From: Michael Eastham <Michael.Eastham@arun.gov.uk>
Sent: 12 August 2020 09:28
To: Planning.Responses <Planning.Responses@arun.gov.uk>
Subject: FW: BE/86/20/NMA - Salt Box

Please upload the email below from the applicant onto Ocella for **BE/86/20/NMA** regarding Salt Box.

SALT BOX SITE - BOGNOR REGIS

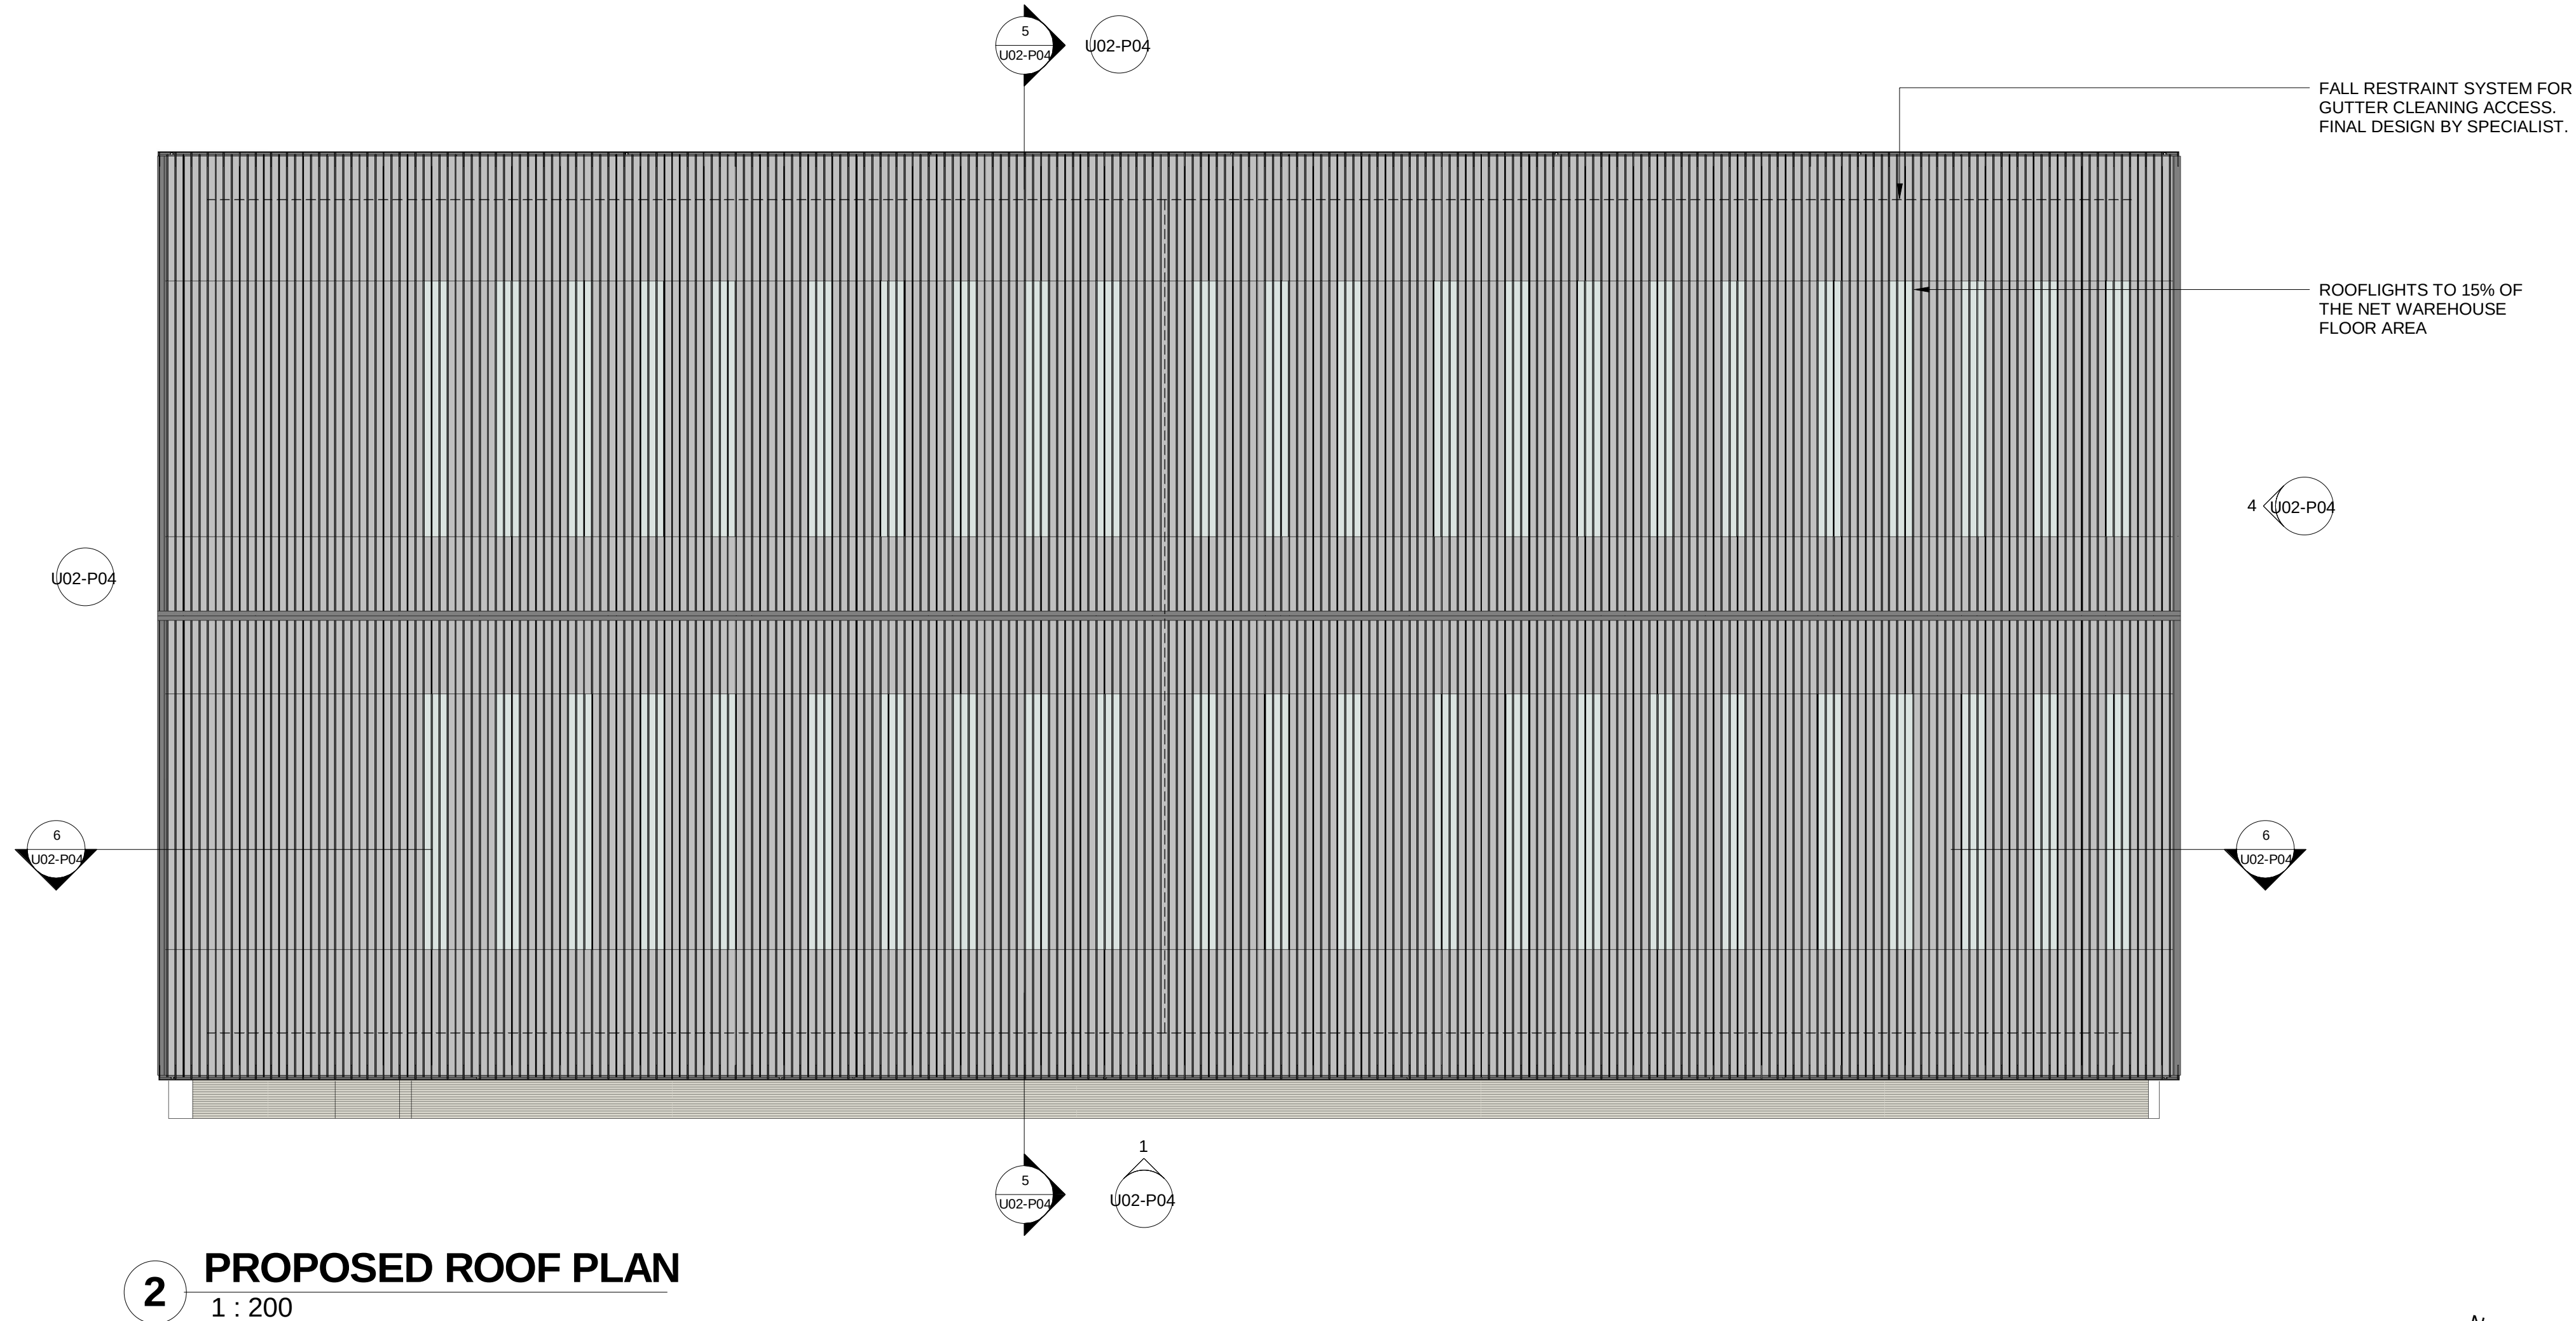
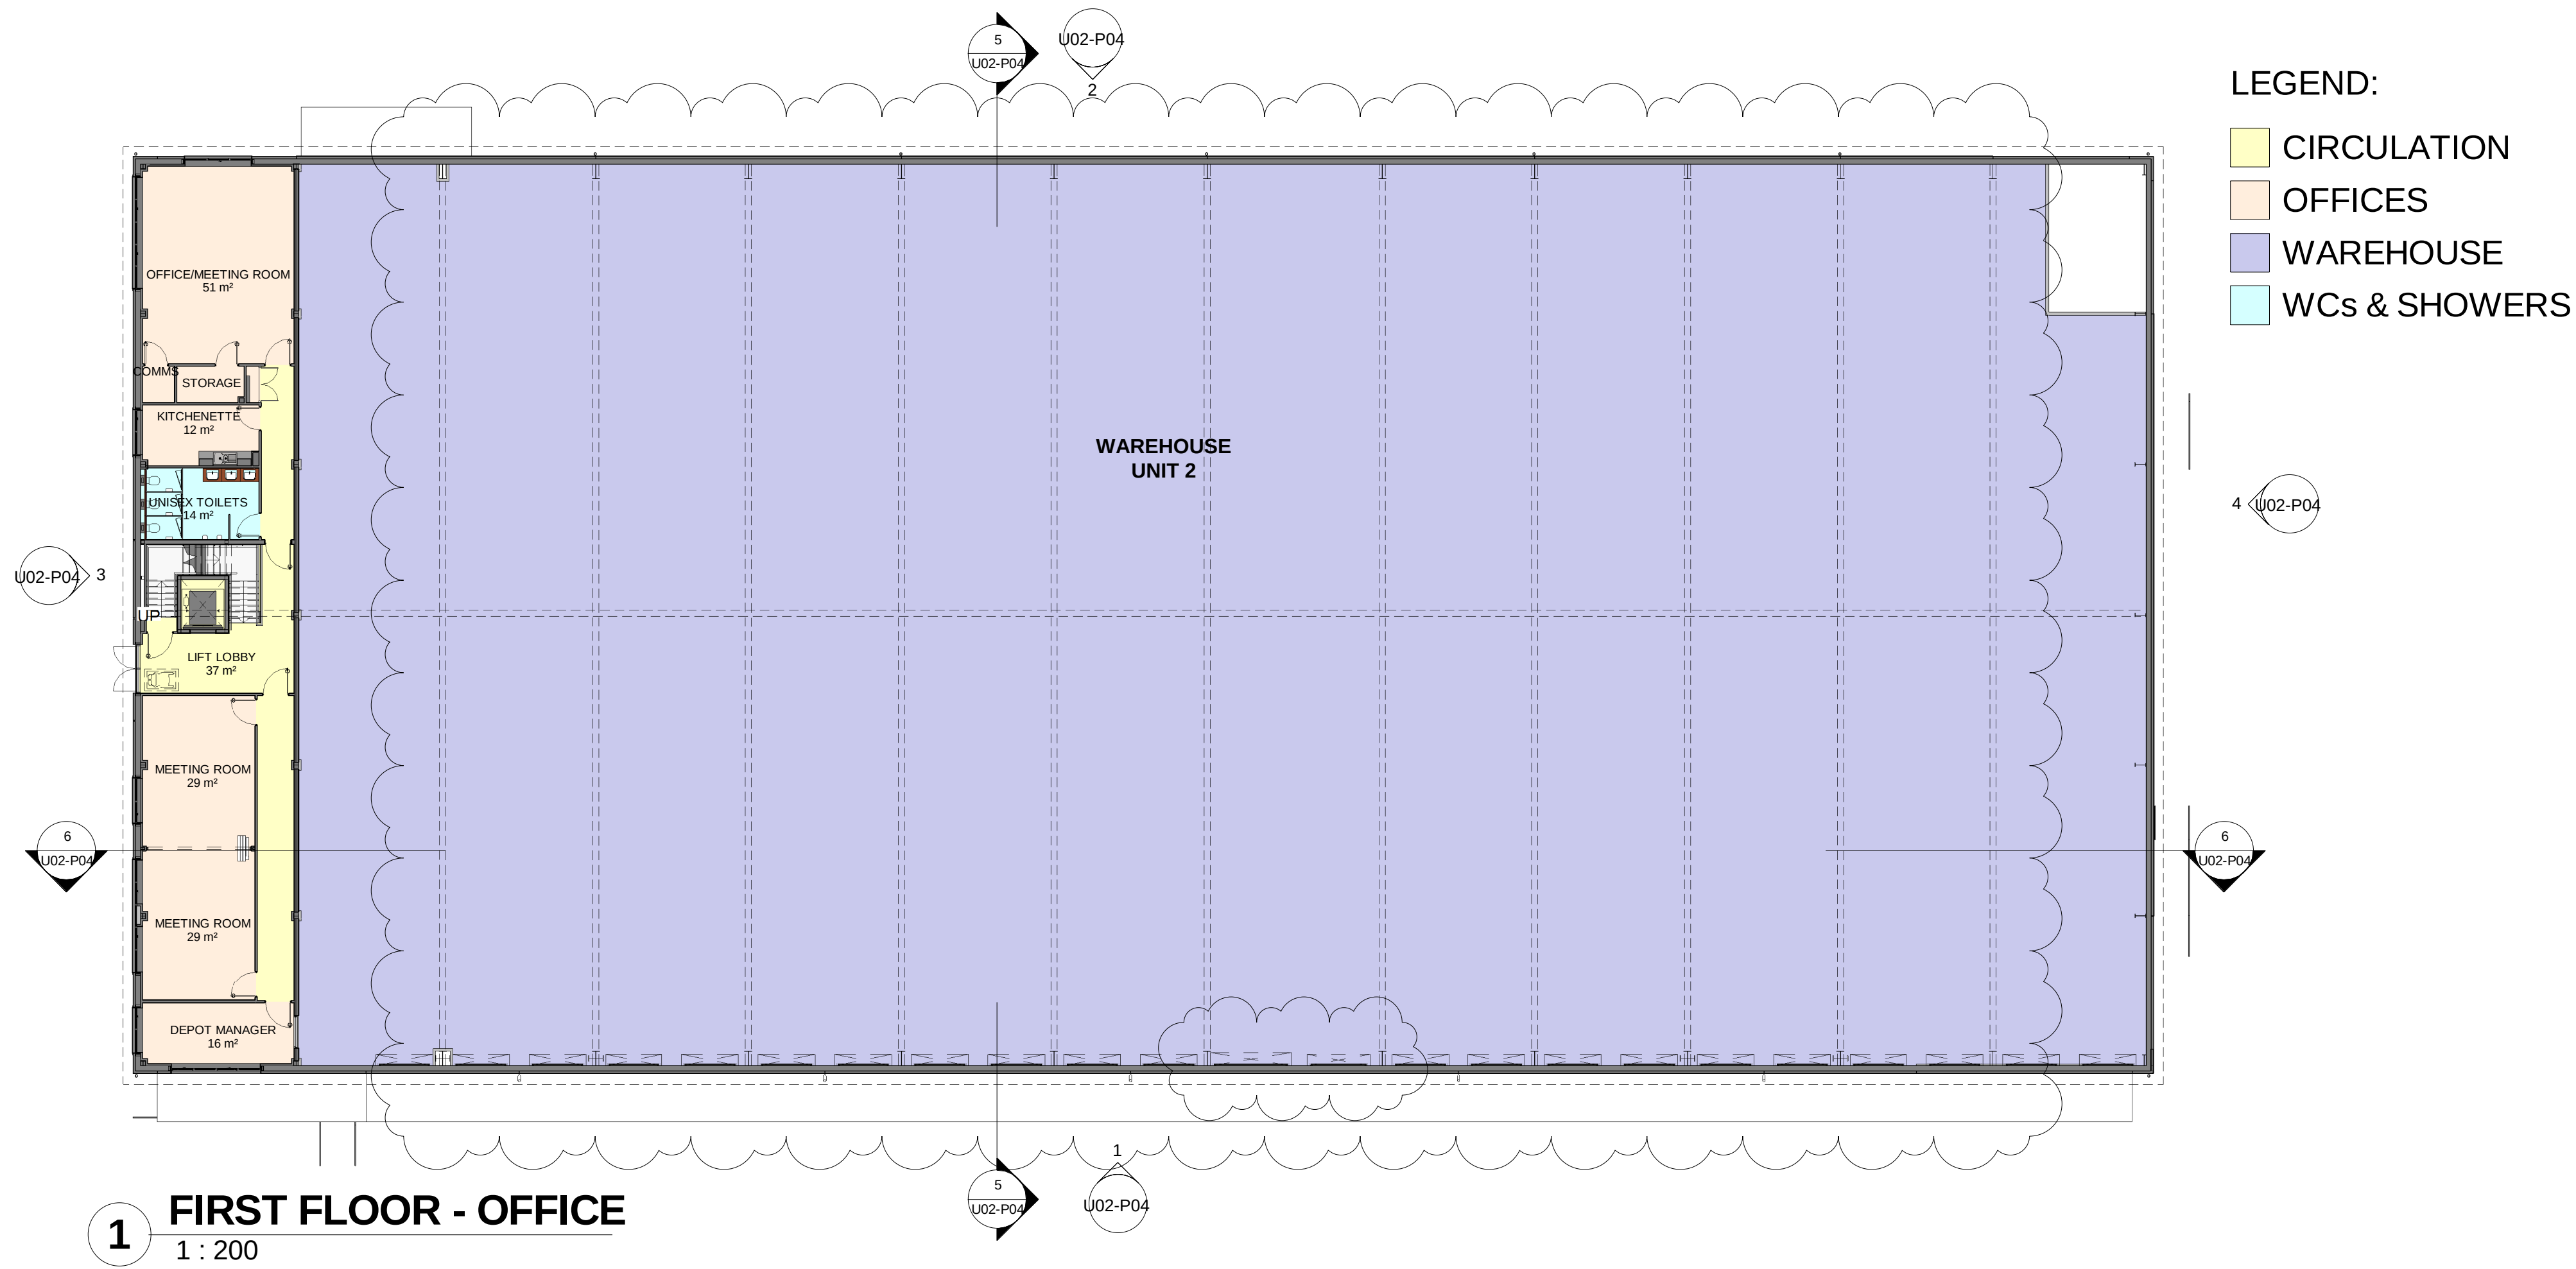
The non-material amendment application (**BE/86/20/NMA**) which you have submitted for Salt Box includes adjustments to the landscape layout and levels, however you have not submitted any plans of the amended landscape layout or details of the revised levels.

Please could you submit the plans of the amended landscape layout and the details of the revised levels and set out an explanation as to why these changes are required.

When I said landscape, I meant the landscape within the confines (and just outside) of the unit 2 demise, so the yard, car-park and other hard landscaping. So only those levels shown on drawing 1744-U02-P02-A.

The levels on the above drawing have been adjusted to suit the levels agreed as part of the drainage conditions, just to make sure the drawing submitted tallied with those discharged already.
